Lime Down

Solar Park

Statement of Common Ground with Environment Agency

Document Reference: EXAM/8.6

Scale: 1:10,000 @ A3

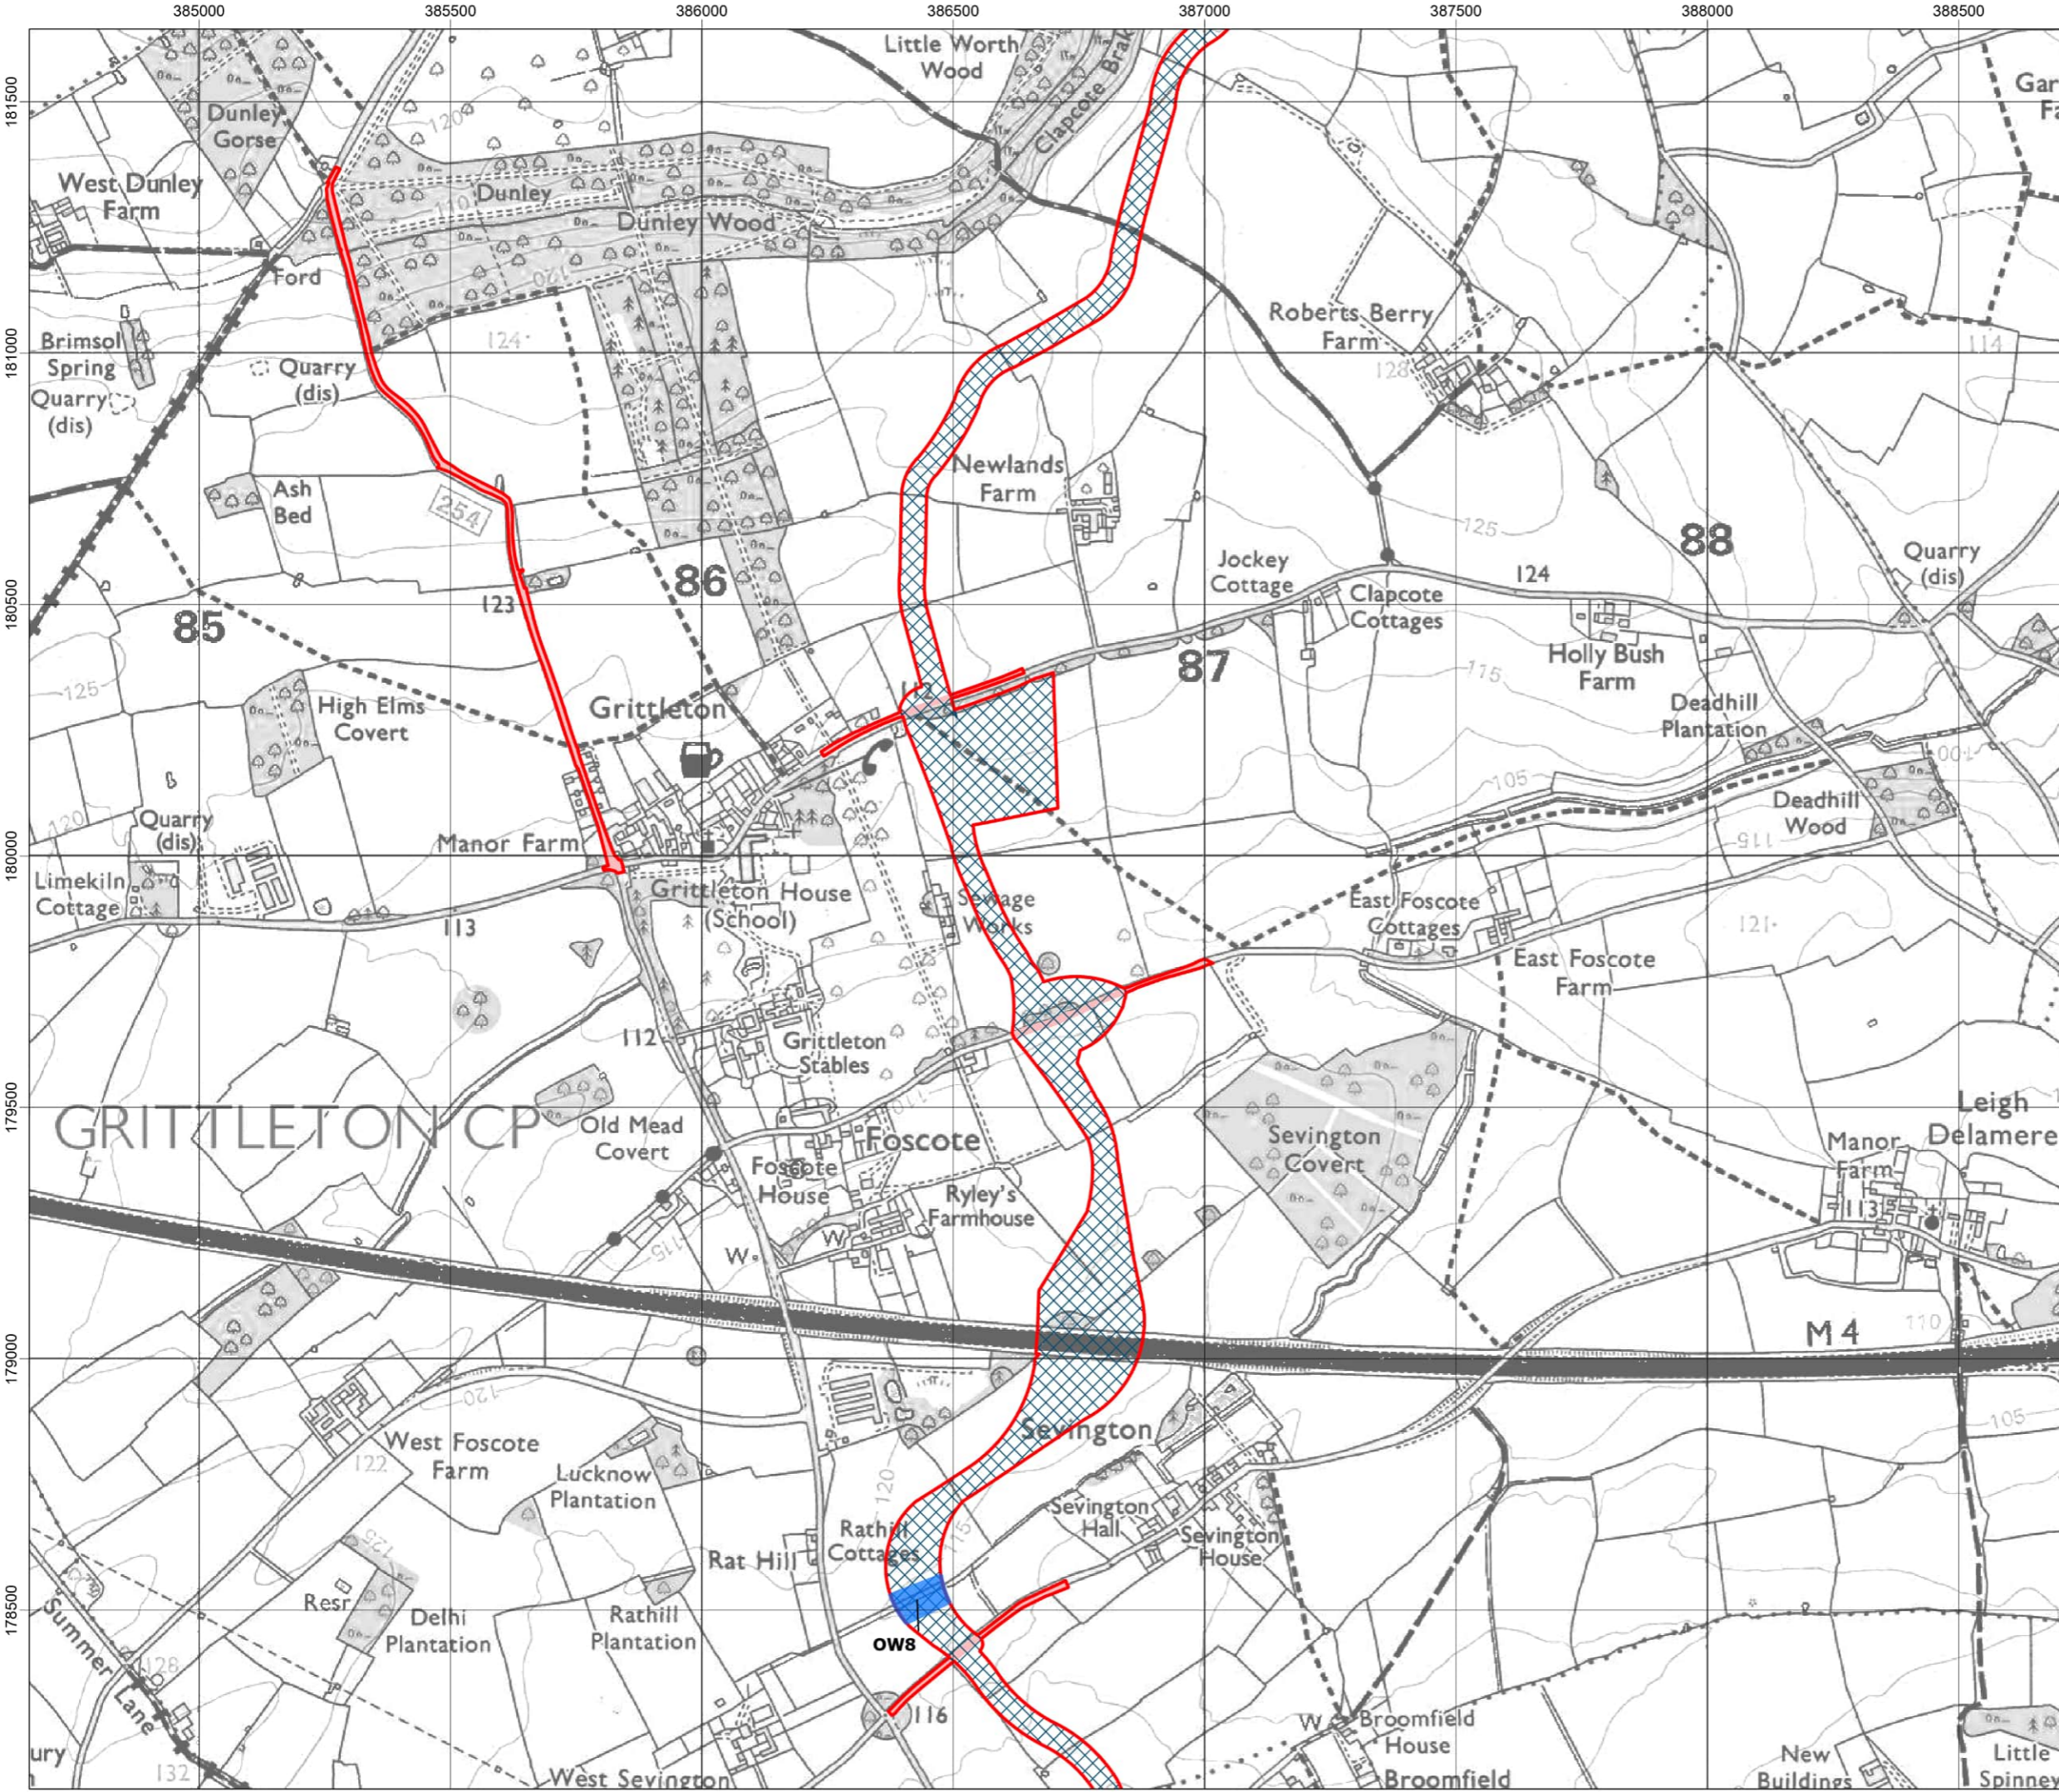
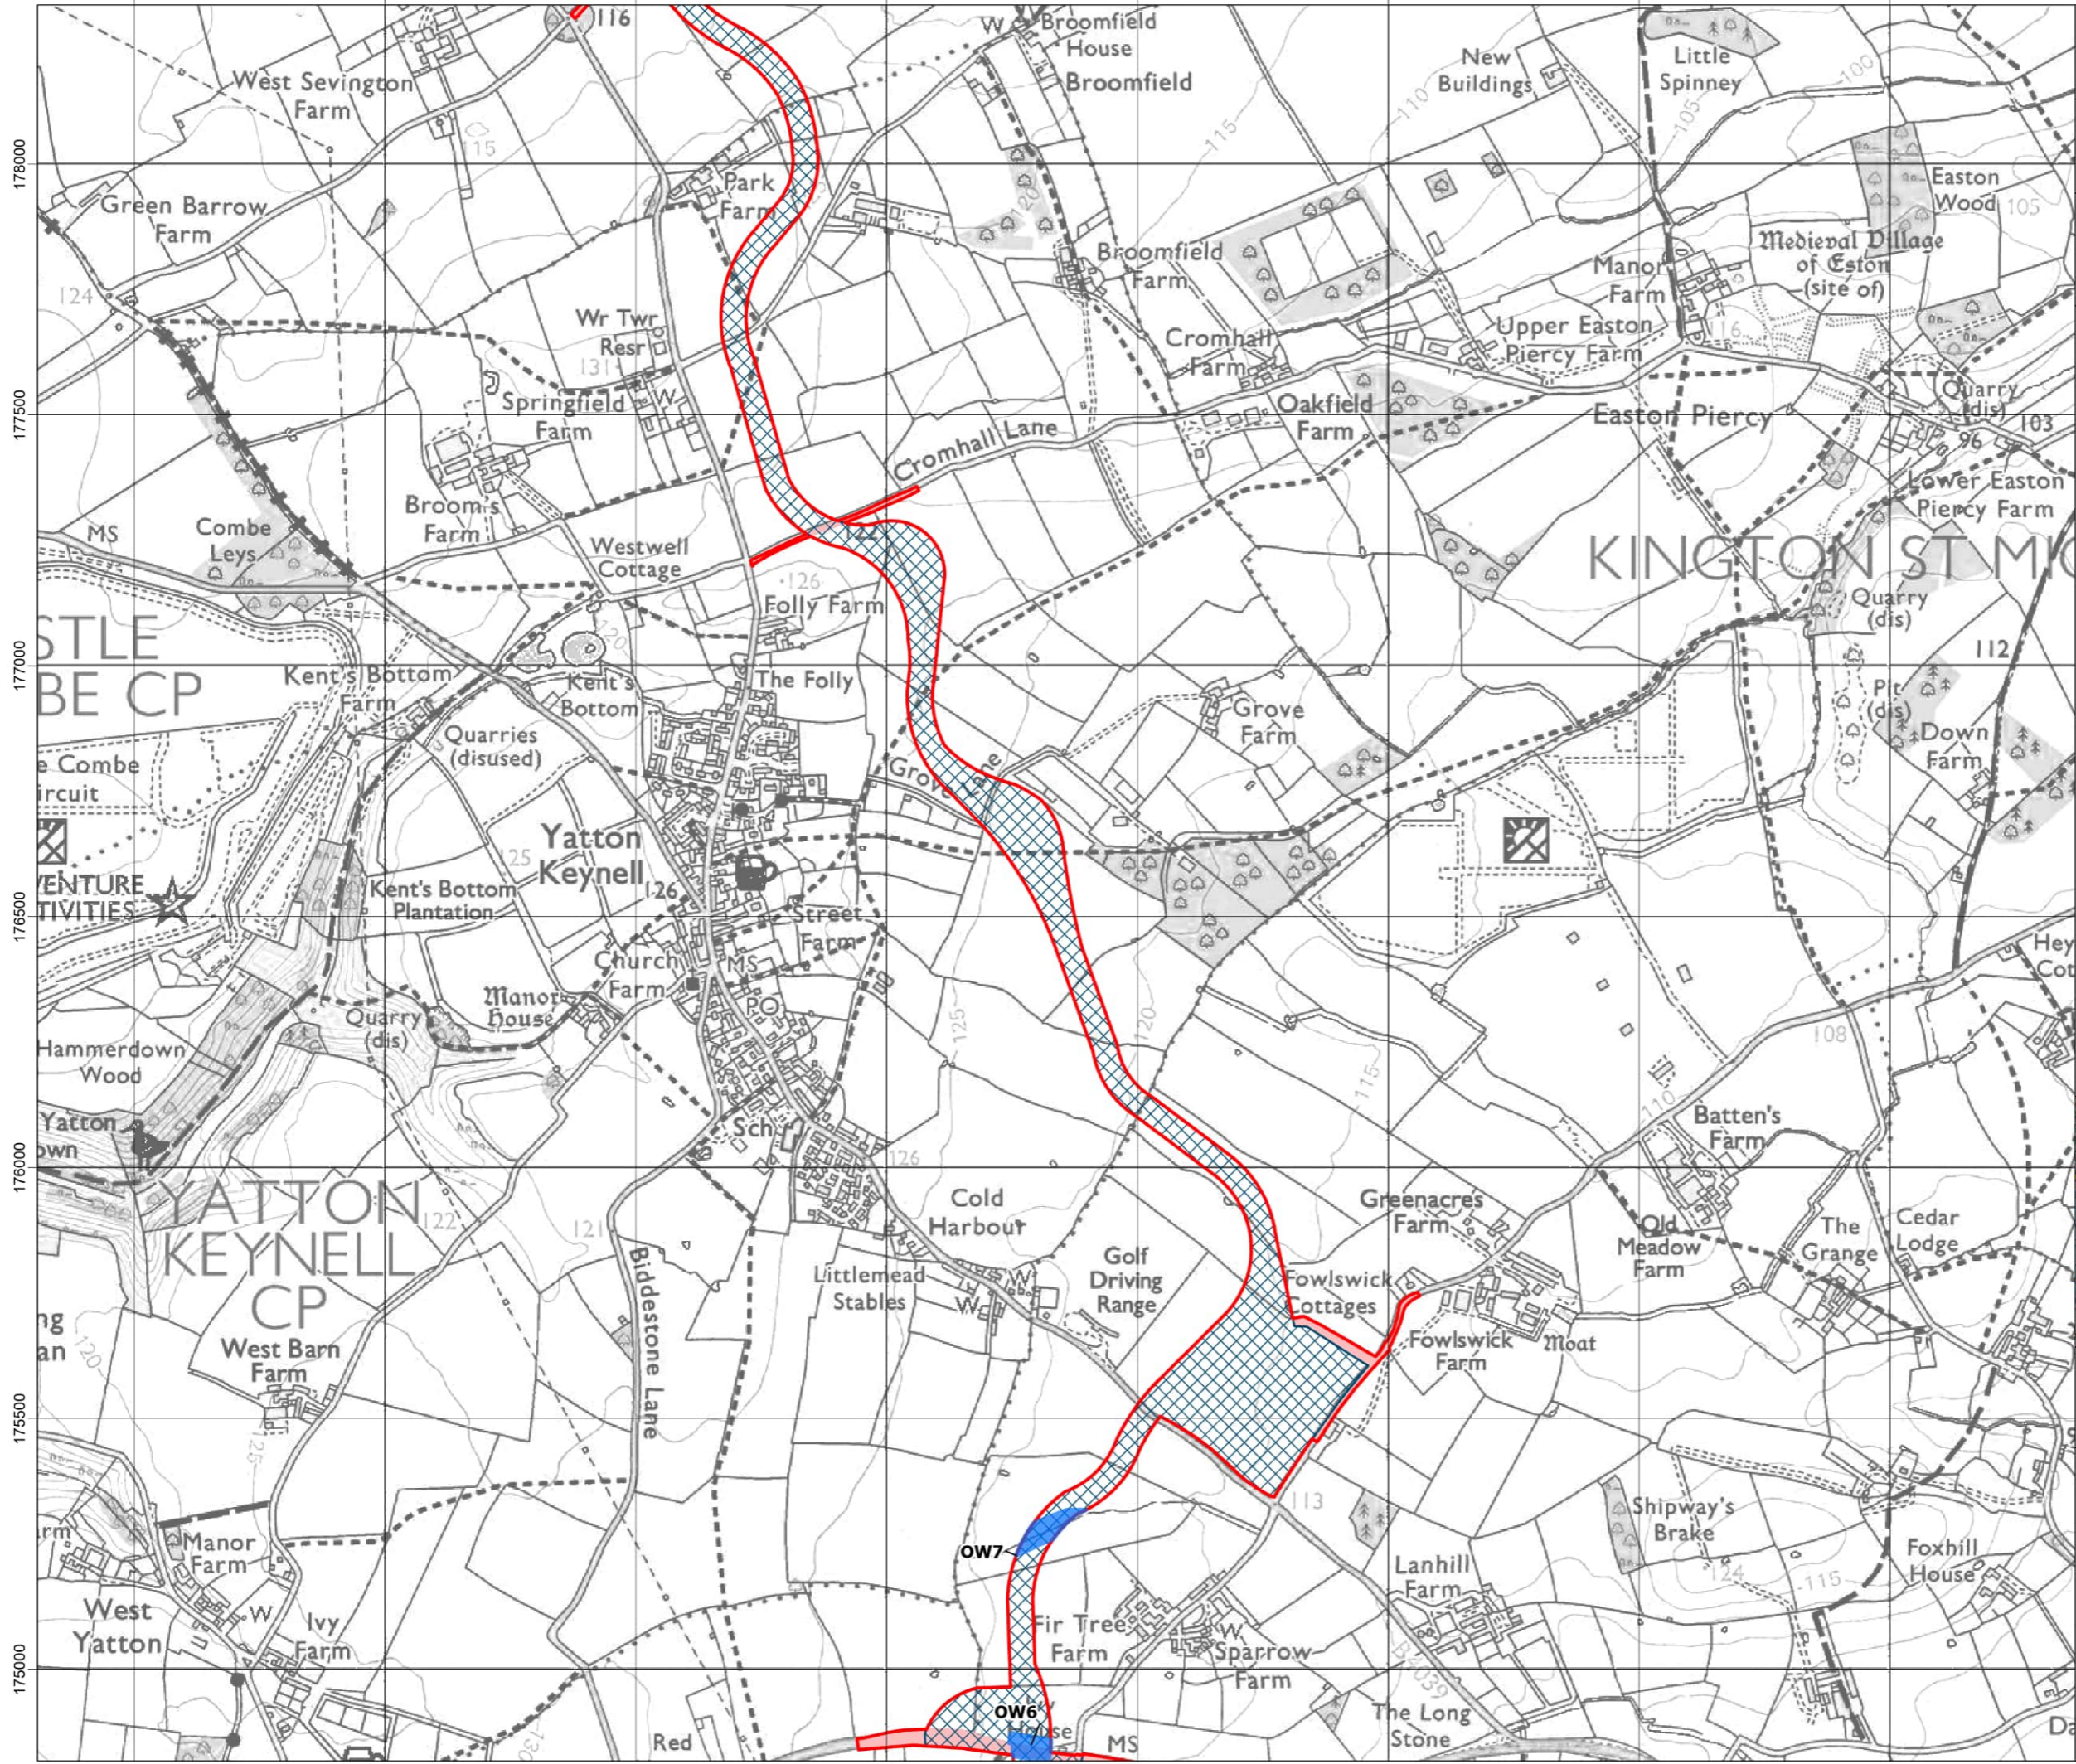
Reference	Sub-topic	EA Position	Applicants Position	Status
3.1.12	Ecological impact from watercourses crossing	<p>Due to the lack of habitat descriptions or photographs of watercourses and the reference to the use of open cut technologies on SM5 (not referenced elsewhere) in Appendix 11-1 Flood Risk Assessment and Drainage Strategy – Lime Down Covering Report; Table 5: Watercourse Crossing [APP-210], the EA is concerned that the ecological impact of these crossings has not been fully assessed and/or communicated in Chapter 9: Ecology and Biodiversity [APP-061], regarding impacts on habitats and associated species.</p> <p>Whilst we agree with the detail set out in paragraph 9.1.47 of Chapter 9 Ecology and Biodiversity [APP-061], there remains a risk that some watercourses where an open-cut method is selected could have a significant impact on fish species—not only eels and brown/sea trout. Of particular concern are crossing reference SM3 and SM5 which are both main river and may provide suitable habitat for fish.</p>	<p>A new appendix to ES Volume 3, Chapter 9: Ecology and Biodiversity was submitted at Deadline 1 which provides habitat descriptions and photographs of all watercourse crossing points, as well as the construction methodology to be used at each crossing point, for clarity.</p> <p>ES Volume 1, Chapter 9: Ecology and Biodiversity [REP1-015] has been revised to include a separate section for Aquatic Invertebrates (excluding white clawed crayfish, which is covered in its respective section), and additional text has been included on aquatic macrophytes within existing sections relating to plants. No significant residual adverse effects are anticipated for either of these species groups, and the revised Chapter was submitted at Deadline 1.</p> <p>Notwithstanding, the Applicant confirms that no watercourse crossing is proposed at SM5 and this has now been removed from the watercourse crossing schedule. This does not alter the assessed flood risk, drainage or ecological conclusions. The Applicant</p>	Under Discussion

Reference	Sub-topic	EA Position	Applicants Position	Status
		<p>The Environment Agency requires the applicant to provide a clear plan and schedule detailing extent and nature of works directly impacting upon watercourses. Provide habitat descriptions and photographs of proposed watercourse crossings and ensure Chapter 9 Ecology and Biodiversity [APP-061 assesses the impact of these, with other documents updated as appropriate.</p> <p>This would provide confidence that the chosen crossing type is appropriate.</p>	<p>will update the relevant application documents as set out above.</p>
